Our ref: XA/2025/100307/01-L01

A46 Newark Bypass – Development Consent Order (DCO) Application

A46 from Farndon Roundabout to Winthorpe Roundabout, near Newark-On-Trent

Deadline 7 (25 March 2025)

Figure -1 Location of flood defense embankment

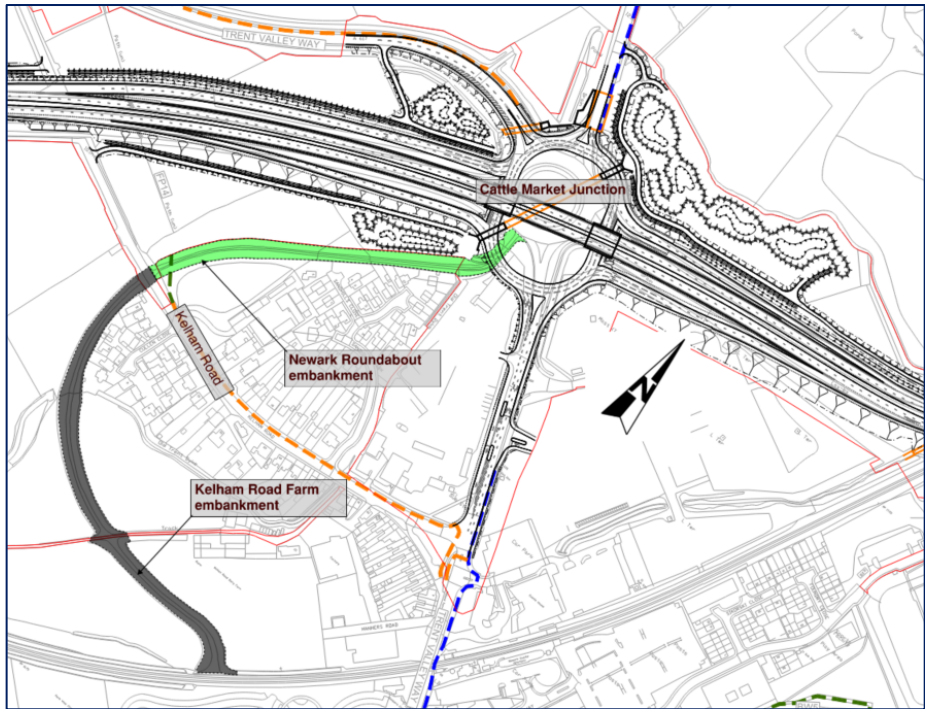
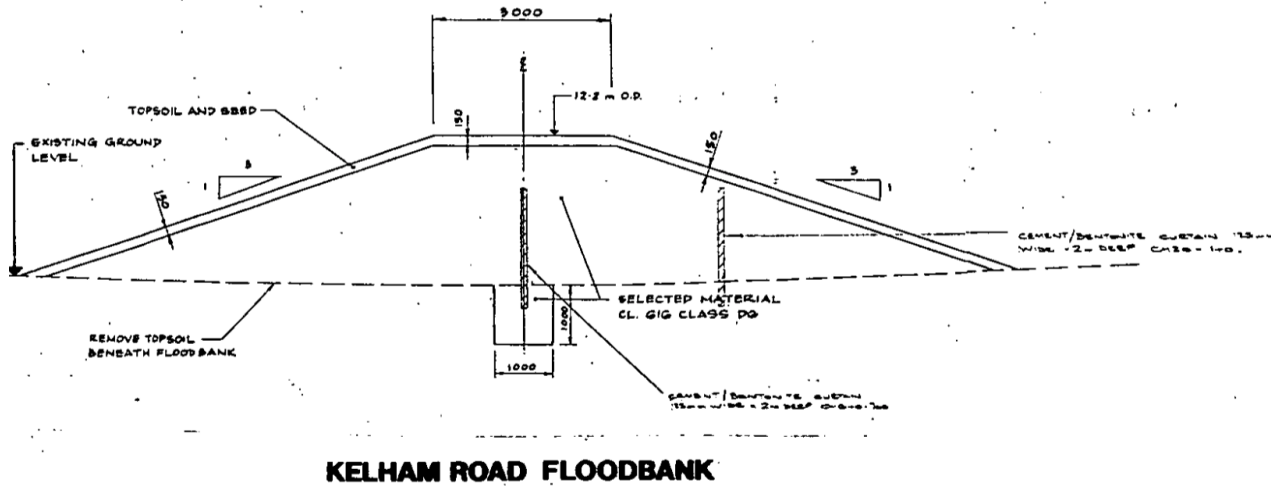
Newark Roundabout / Cattle Market Junction flood defence embankment

The Applicant presented to us, in a virtual meeting on 11 March 2025, details relating to the Scheme's interaction with the Environment Agency maintained flood defence embankment at Kelham Road. Following this meeting, further detail was provided which we have reviewed.

We have confirmed to the Applicant we are satisfied that the detail provided to us demonstrates the new tie-ins to the existing flood defence embankment will not adversely impact the stability and level of protection that the embankment provides. The works will also require a flood risk activity permit (FRAP) therefore the proposals will be finalised as part of the detailed design and permitting process.
